STATEMENT TO SUPPORT THE HOUSEHOLDER PLANNING APPLICATION RESUBMISSION 10 MANOR ROAD, WHALLEY, LANCASHIRE

Following the refusal of the previous application this statement is written to highlight the amendments to the proposal which aim to resolve the reasons for the decision.

PROPOSED ELEVATIONS

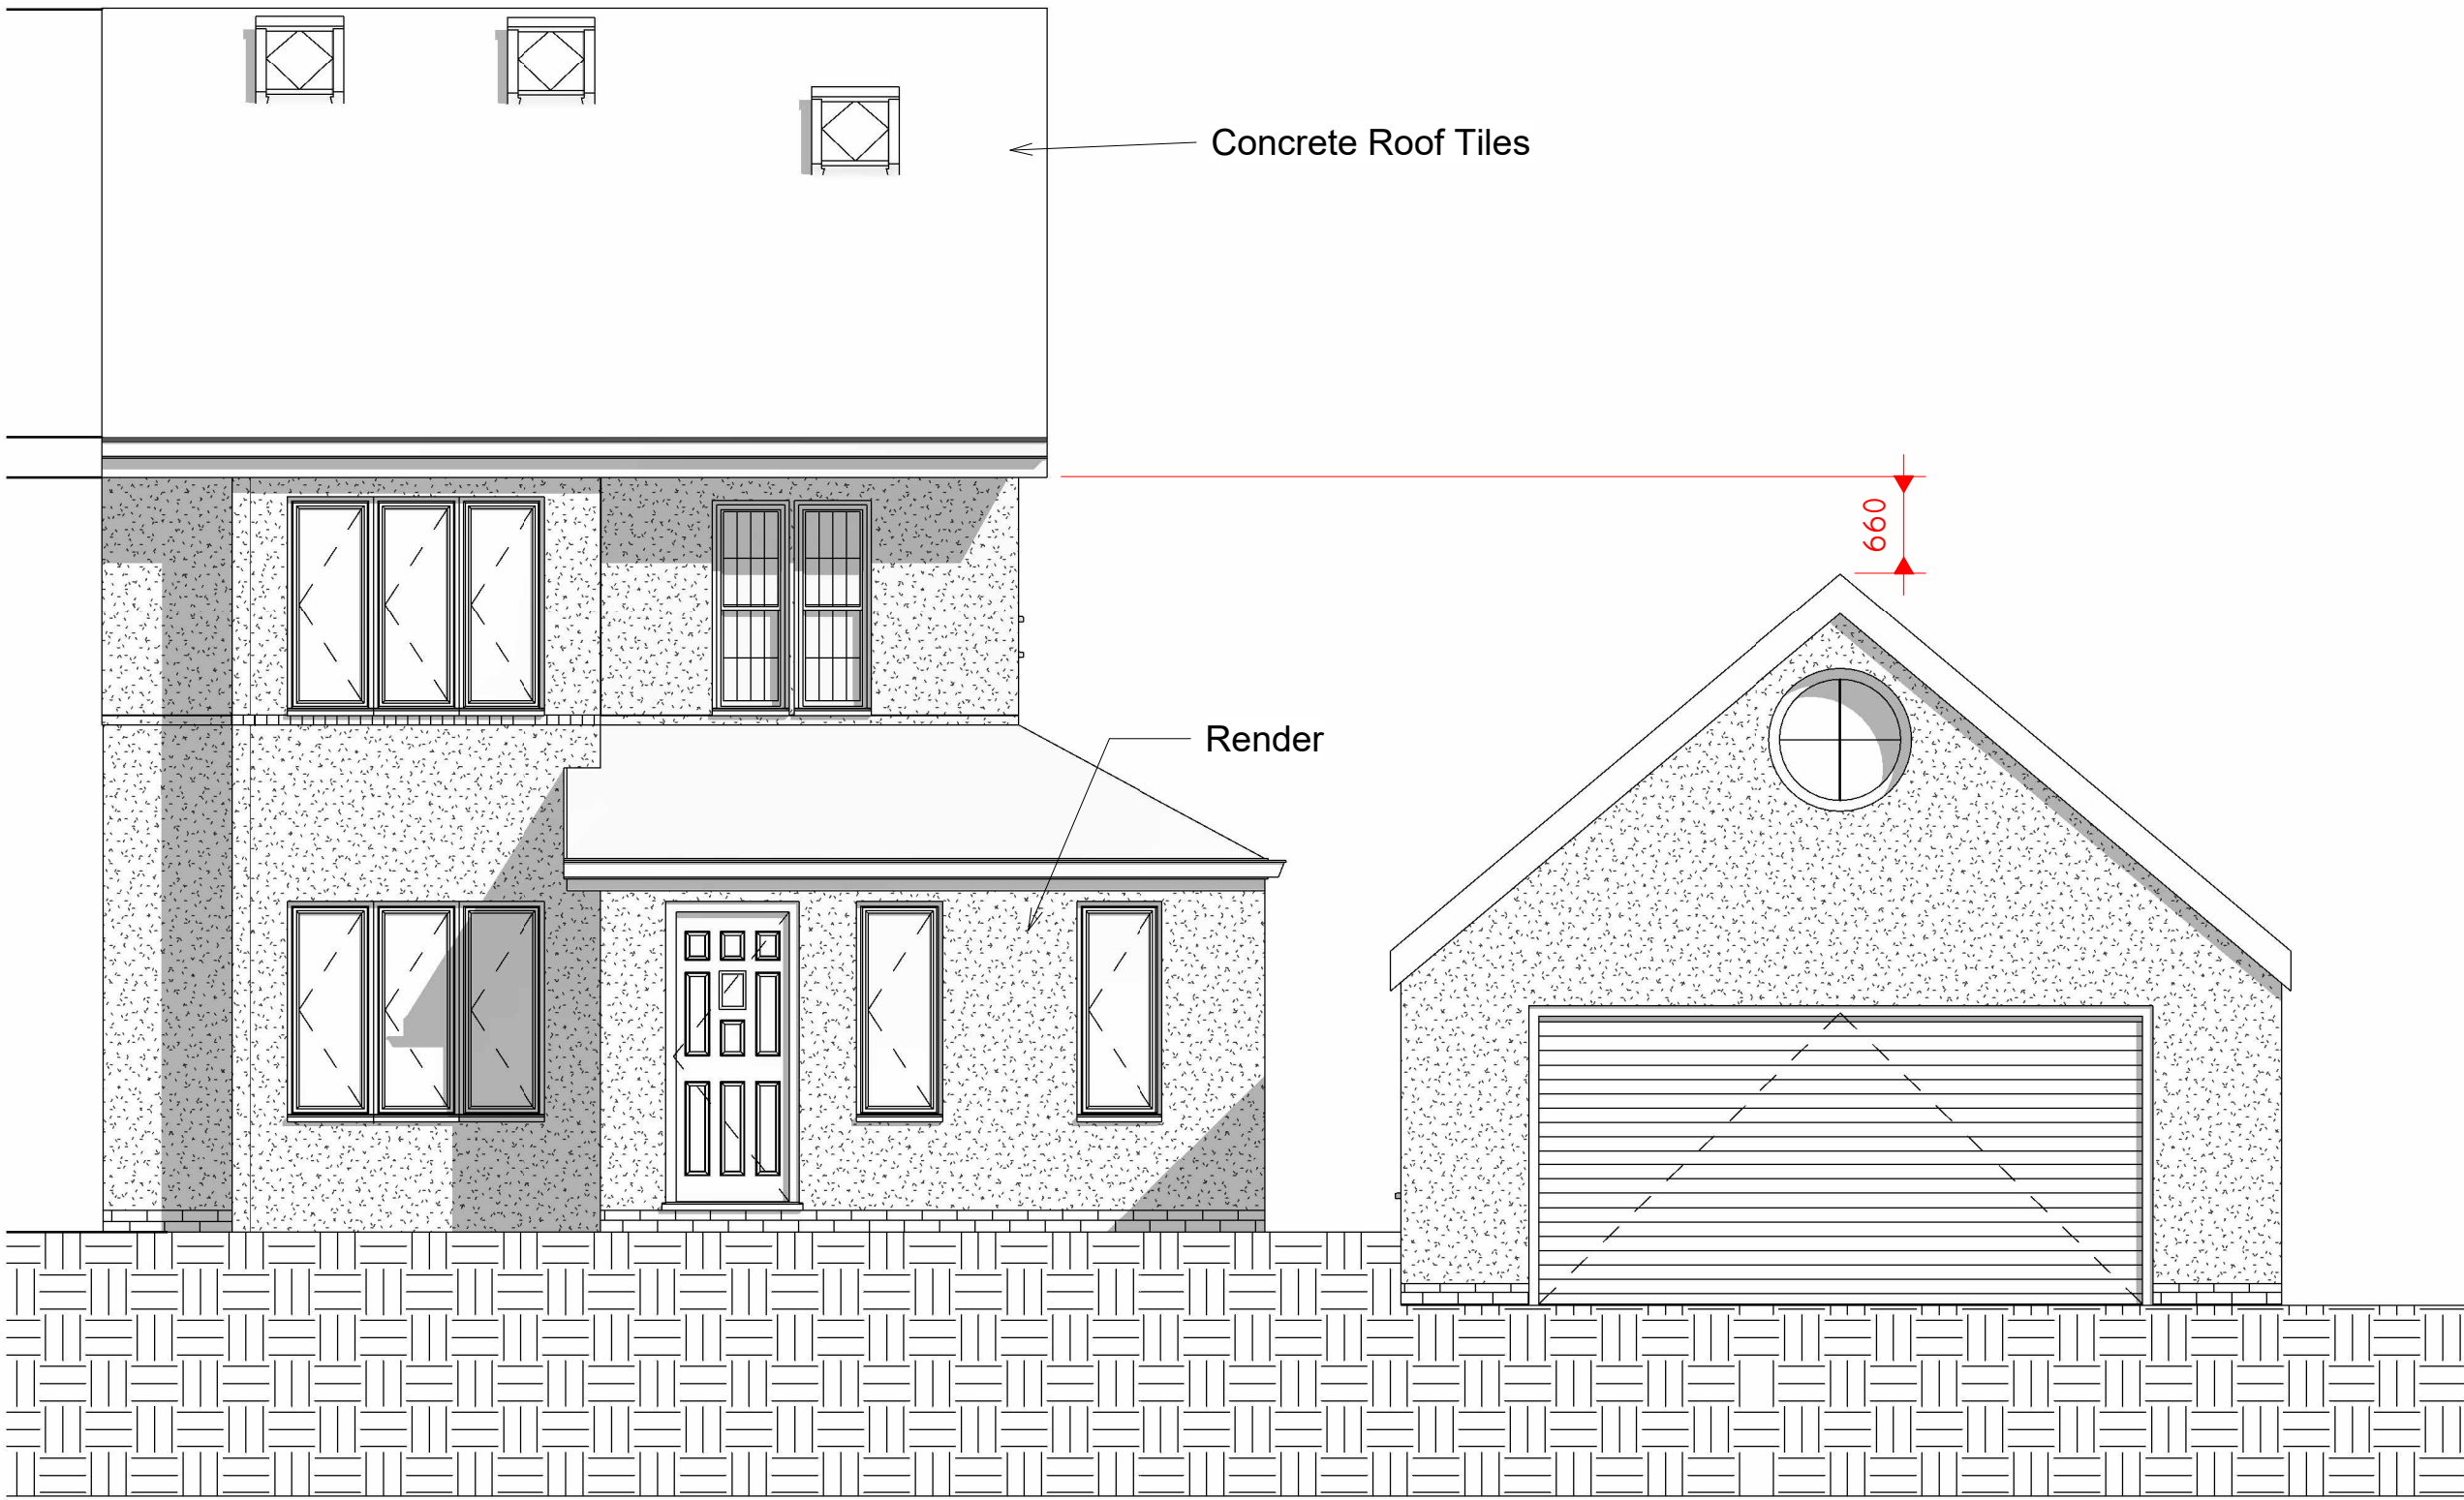
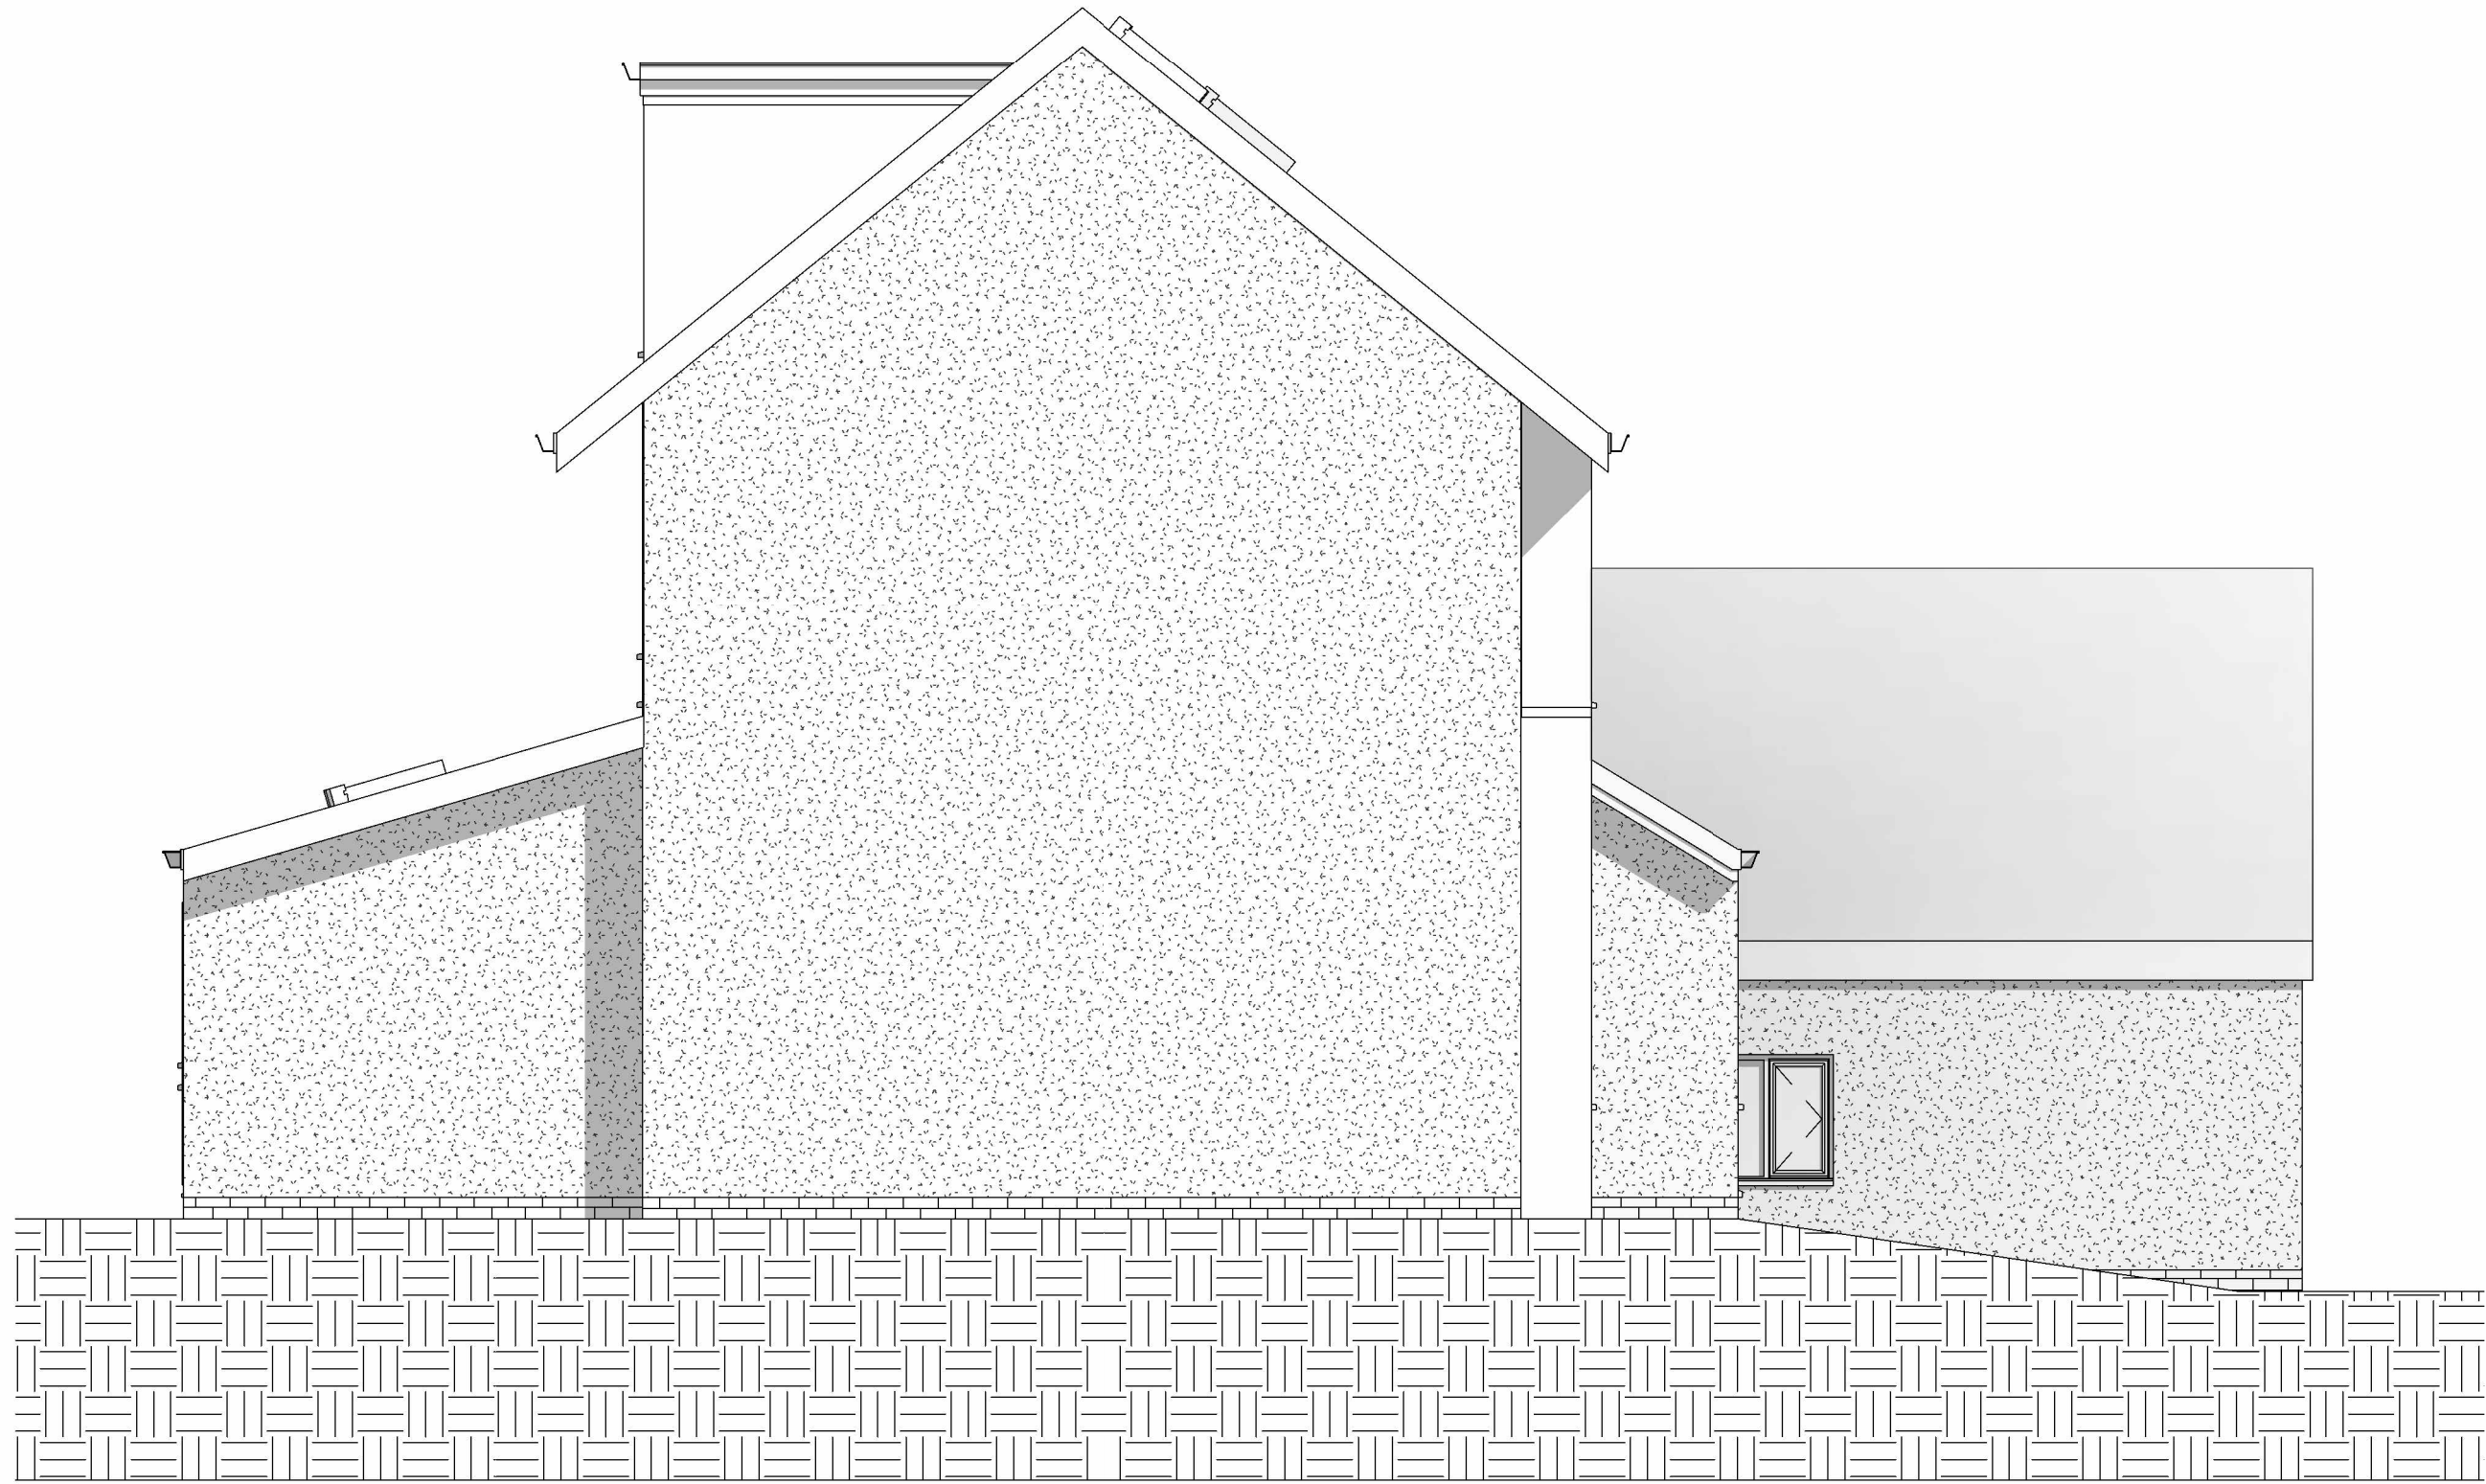
In this instance, the proposal involves the addition of a two storey garage structure which would stand at just over 5 metres in height meaning the roof ridge of the garage would be sited above the eaves of the host property. In addition, the garage's footprint would be offset to the footprint of the main dwelling therefore the proposed garage would be disruptive to the symmetry currently shared between the property and the existing detached garage.

Furthermore, the replacement single storey wrap around extension would incorporate a flat roof design which would be largely at odds with the pitched roof design recently installed on the property. In addition, the incorporation of large glazed openings and composite timber boarding to the front elevation of the proposed extension and the entire first floor level of the property would be entirely at odds with the brick and pebble dashed render elevations and casement style windows installed on neighbouring properties within the immediate locality.

Moreover, all of the above works and alterations would be read in concert with the largely unsympathetic hipped to gable roof conversion and rear dormer currently under construction at the property. It is proposed to clad the rear dormer in a standing seam zinc finish which would introduce another different material and finish, further exacerbating the visual impact.

As such, the cumulative visual impact of the two storey garage, single storey wrap around extension, reconfigured window fenestration and installation of composite timber boarding and zinc cladding would collectively read as an over bearing and unsympathetic modification of the host property, with the proposed works and previously approved works reading as a significant over development of the application site. Furthermore, all of the application property's elevations are viewable within the public realm therefore the visual impact of the proposed development would be pronounced.

The garage ridge height is 5m and 0.5m below the eaves of the host dwelling. The footprint remains as existing as the garage is to be redeveloped with a loft space. The eaves is raised 0.3m and the existing brick facings are shown as fully rendered. The roof has been re-designed as a gabled arrangement which matches the appearance of the house which has been reconstructed recently from a hipped arrangement to a gable end property.

The wrap around (replacement) extension now incorporates a mono pitch (hipped) roof design. The walls are fully rendered with a brick plinth and the glazing proportions amended.

The rear dormer is shown as clad with a grey composite boarding to blend with the concrete roof tiles of the main roof. This minimises any visual impact and is a more sympathetic solution.

The revisions demonstrate that the cumulative impact has been significantly reduced by virtue of retaining the garage in it's existing position and redeveloping the structure. The removal of timber boarding to the elevations to be replaced with a render finish and the continuation of a pitched and hipped mono pitch wrap around to the house at ground floor support this.
